**WEST SUSSEX COUNTY COUNCIL
STRATEGIC PLANNING CONSULTATION**

SUBJECT: Y/22/14 - Outline Application with some matters reserved for a proposed residential development of site with 1 x 4 bedroom house, 13 x 3 bedroom houses 3 x 2 bedroom houses & 1 x 2 bedroom flat over garages, incorporating parking & access to main road, via a redefined alignment of Kings Close & Highway improvement works at existing crossover.

Land At, Kings Close, Yapton, West Sussex

PROPOSED ACCESS IMPROVEMENTS - scale 1:250

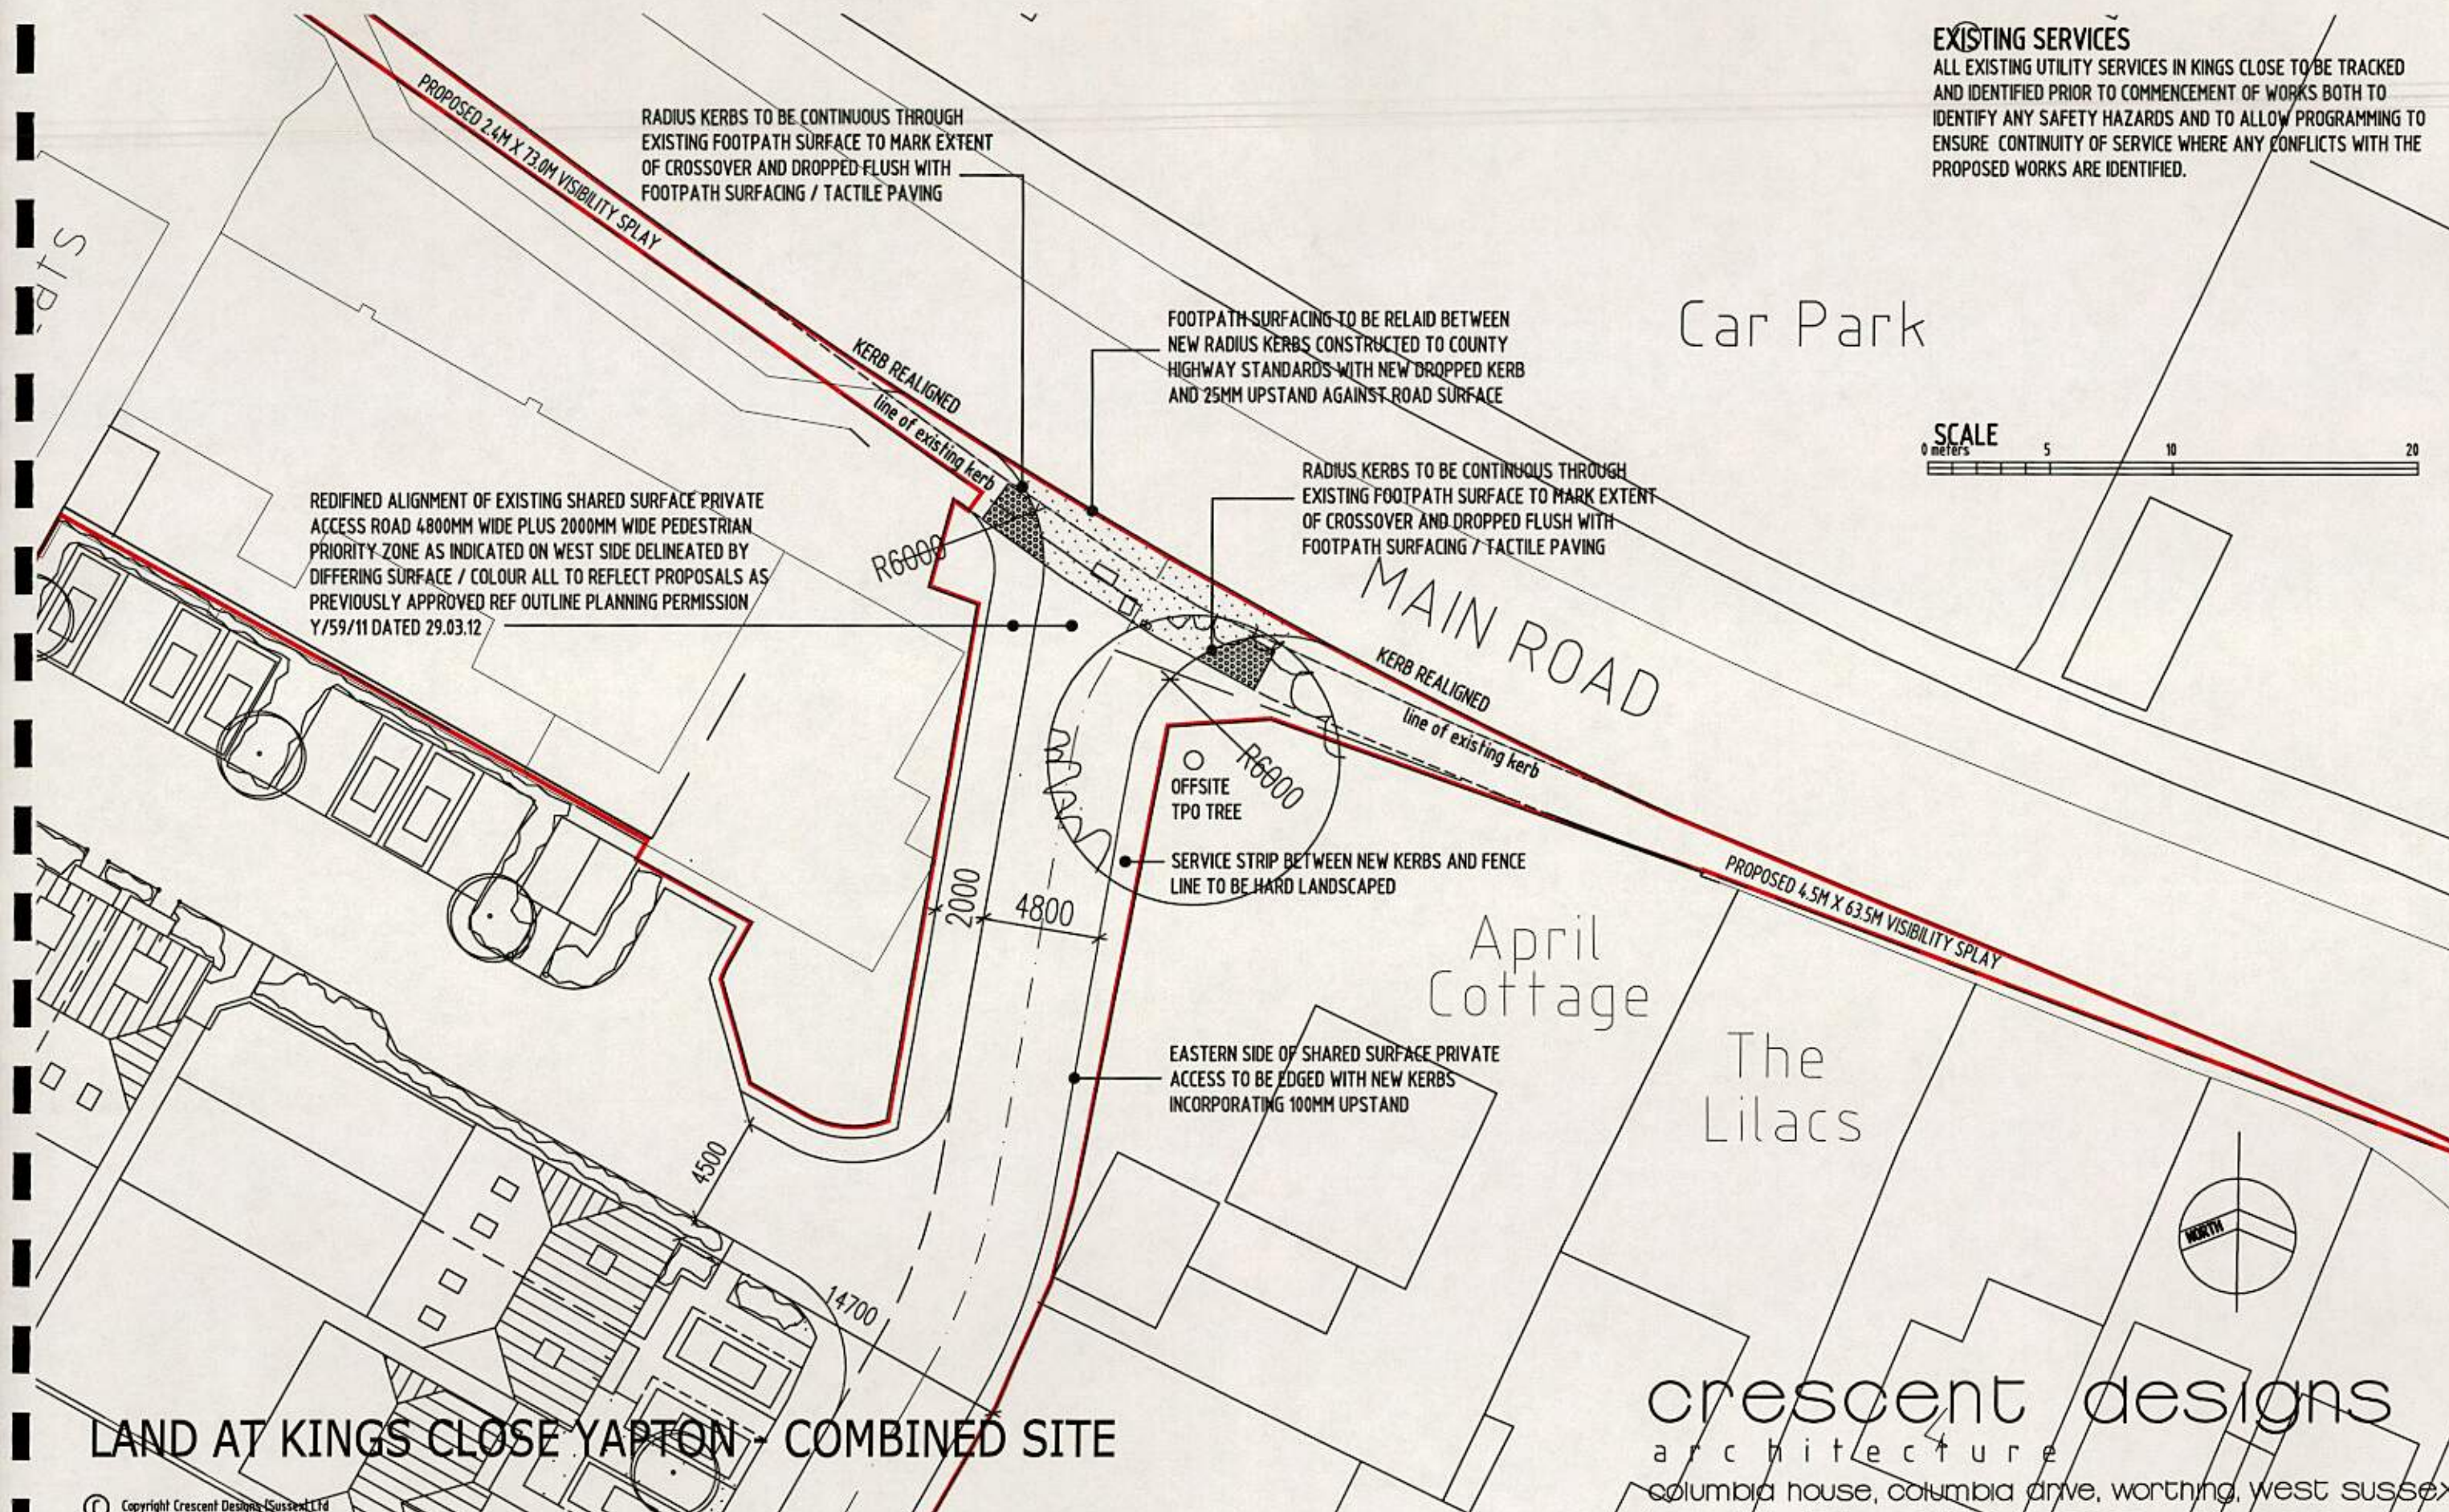
The existing access to Kings Close will be re-defined and aligned to provide a clearer point of access into the close. Improvement works include the re-alignment of the existing kerb-line on Main Road, incorporating new 6000mm kerb radii, and tactile paving.

Drawing 1320-01 provides evidence that visibility splays at the existing access are above the 43m recommended in Manual for Streets (MfS) for roads with vehicle speeds of 30mph. During a visit to the site it was noticed the visibility splay to the west of the access, encroaches into the existing parking lay-by. This is in regular use as it serves the local Co-op Store and other local shops along Main Road. MfS guidance suggests that the impact of obstacles to visibility in built up areas is common, yet it does not appear to create significant problems in practice. WSCC raise no objection to the proposed point of access.

PROPOSED ACCESS AND PARKING LAYOUT PLAN - scale 1:250

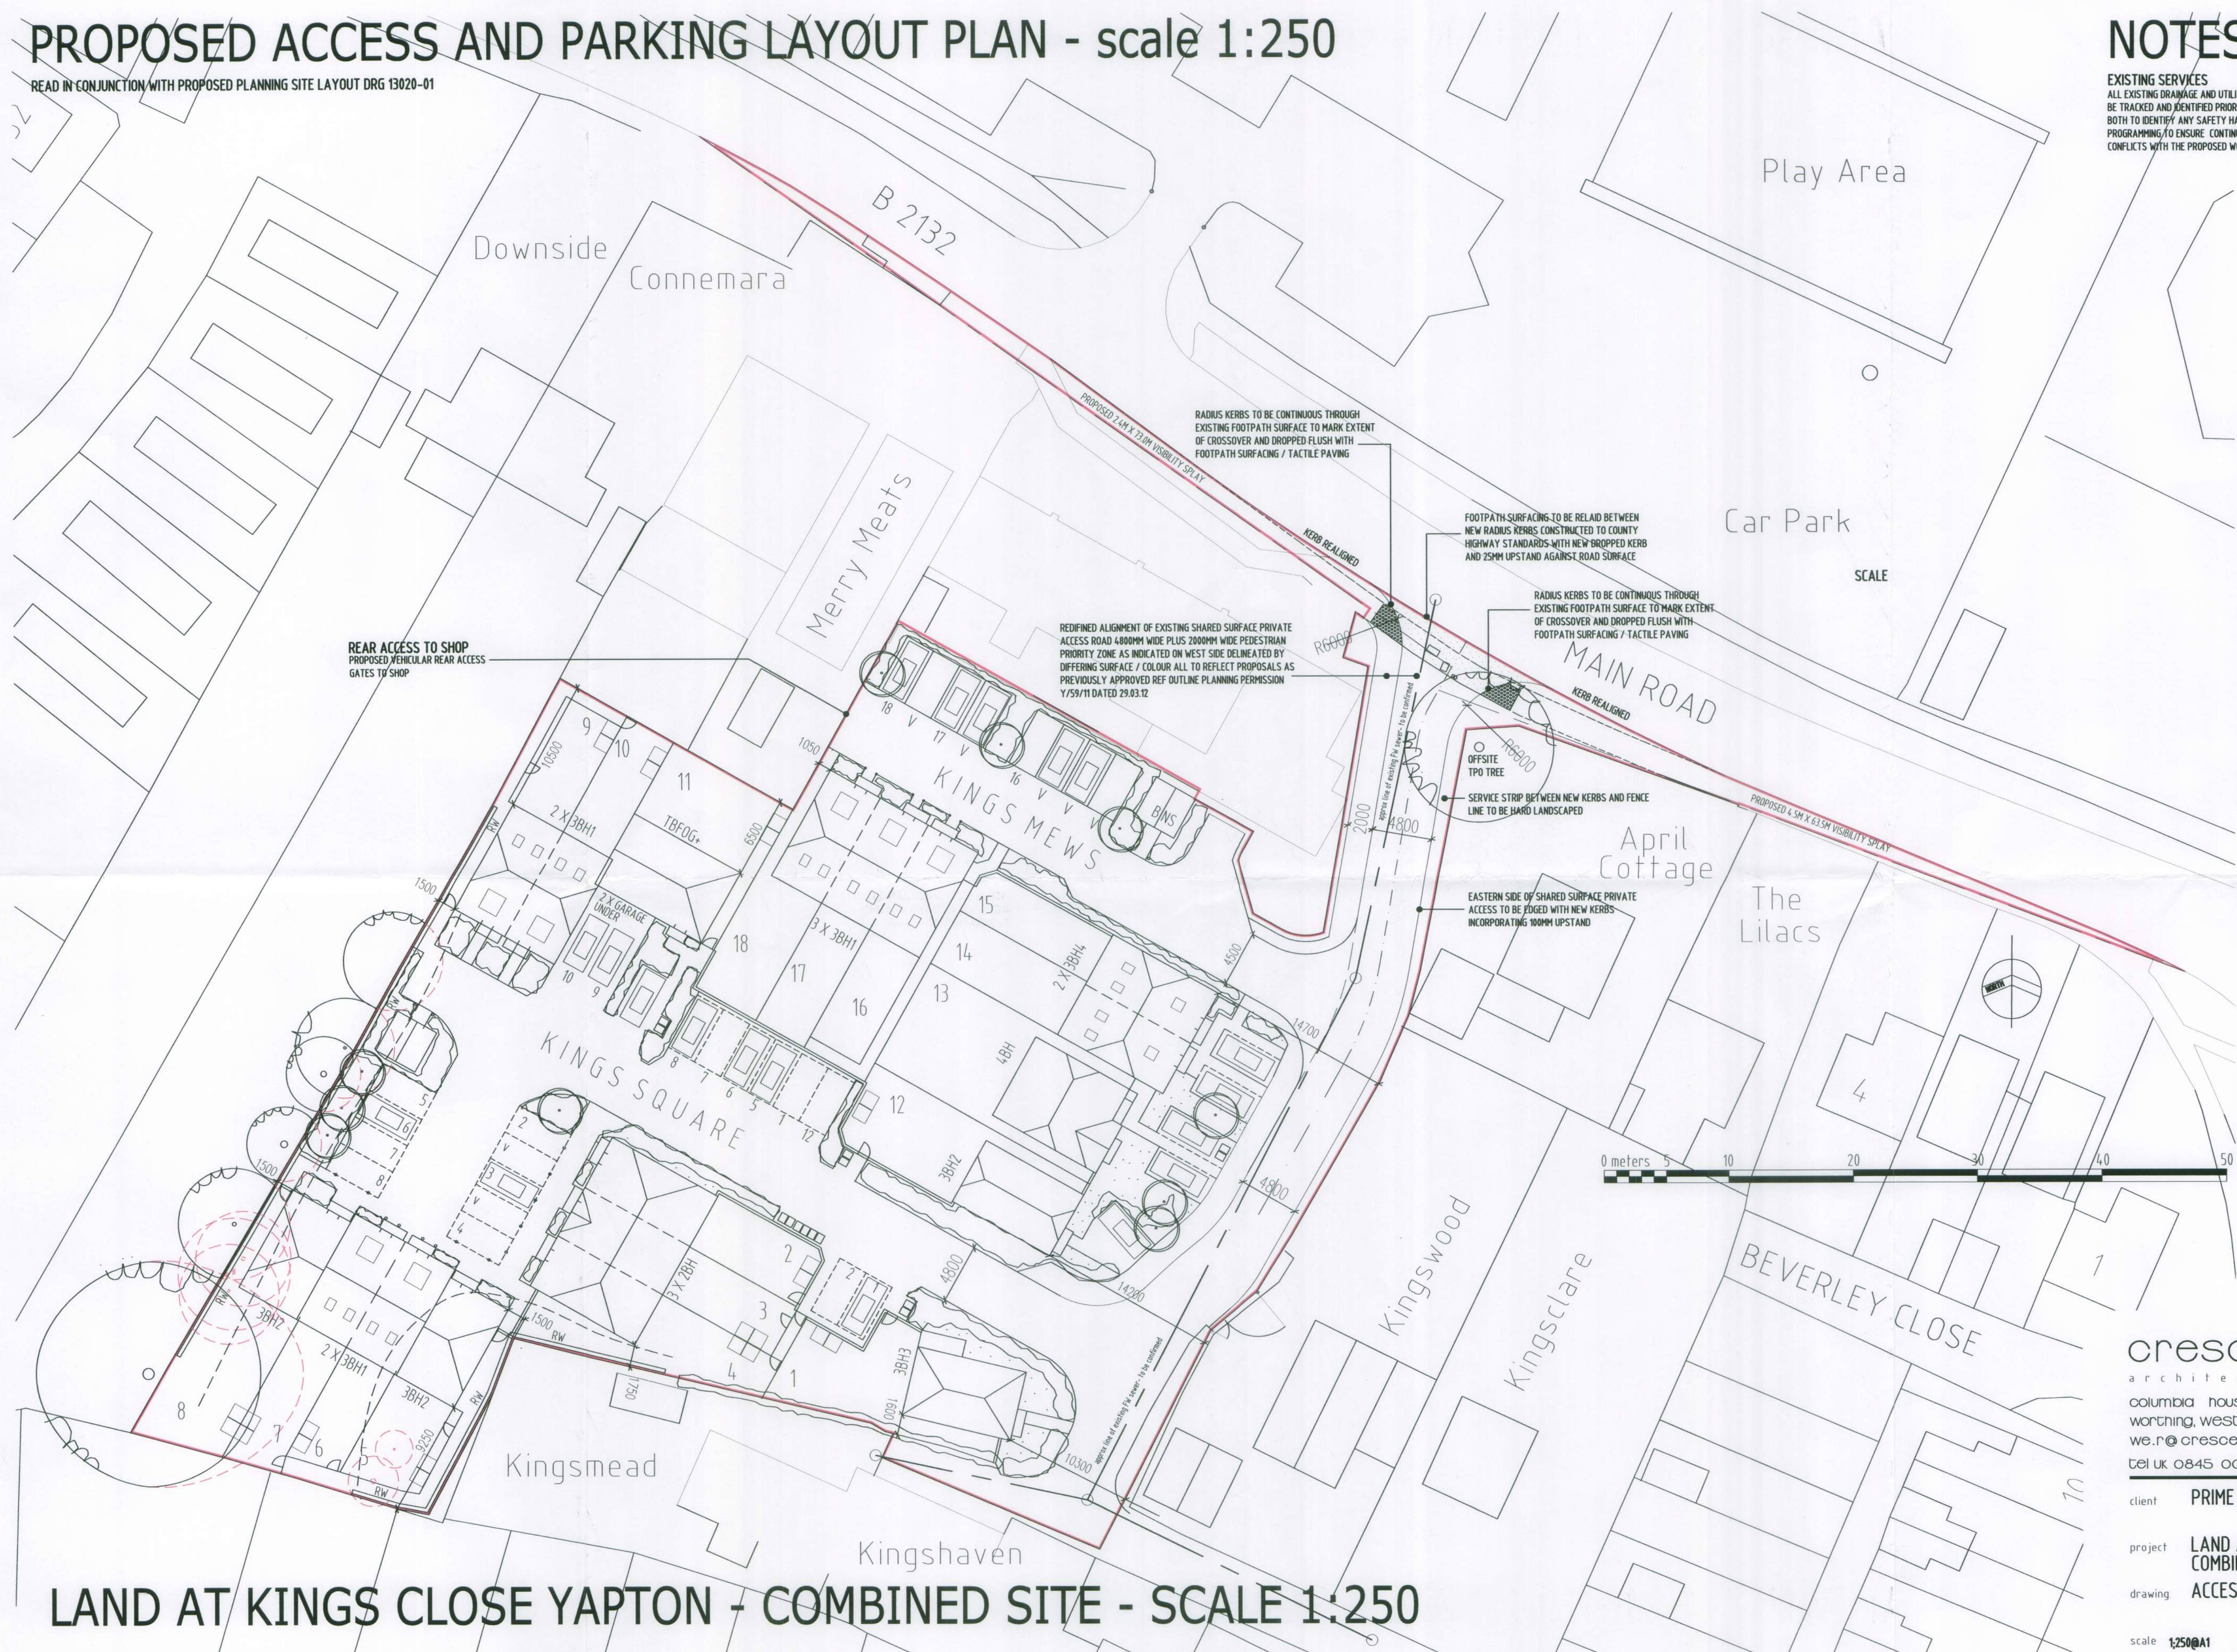
The proposed layout indicates a shared surface layout will be built. However the drawings and plans provided do not show the extent of highway adoptions and where the shared surface begins. It is not clear what materials or features will be used to mark this change from public highway to private. The eastern side of the proposed 'shared use access road' proposes a kerb edging of 10mm, which needs to be increased to 40mm if it is to be classed as a shared surface. The proposed service strip also appears too narrow, the LHA recommend 2m, or 1m either side. It is not clear where this is intended.

If the road is to adopt a shared surface layout the inclusion of a pedestrian priority zone is confusing. Is this a formal footway? A footway would require kerb up stands of 125mm as a minimum, but the inclusion of a footway would not follow a shared surface layout. If it is a footway the LHA have concerns. It is too narrow outside Plot 15 and on the corner of the Co-op site and it does not link well into Plot 1, where no footway is provided.

Please confirm if the layout will be shared use and if it is what these pedestrian priority zones are? Are they service margins? And if so can these be indicated on the drawings.

The proposal to provide 35 car parking spaces, including 7 visitor spaces, has been reviewed using the WSCC car parking demand calculator. The calculator indicates that based on the parking provision below the recommended number of spaces is 28, plus 10 visitor parking spaces. Spaces are 2.4m x 4.8m and meet recommended standards for width and length. Therefore WSCC are satisfied that the proposed parking provision meets maximum standards.

A Stage One Road Safety Audit needs to be carried out as the Local Highway Authority consider this to be an intensification of use of an existing access. The audit should include swept path analysis of the turning heads to ensure these are capable of accommodating a large refuse vehicle.
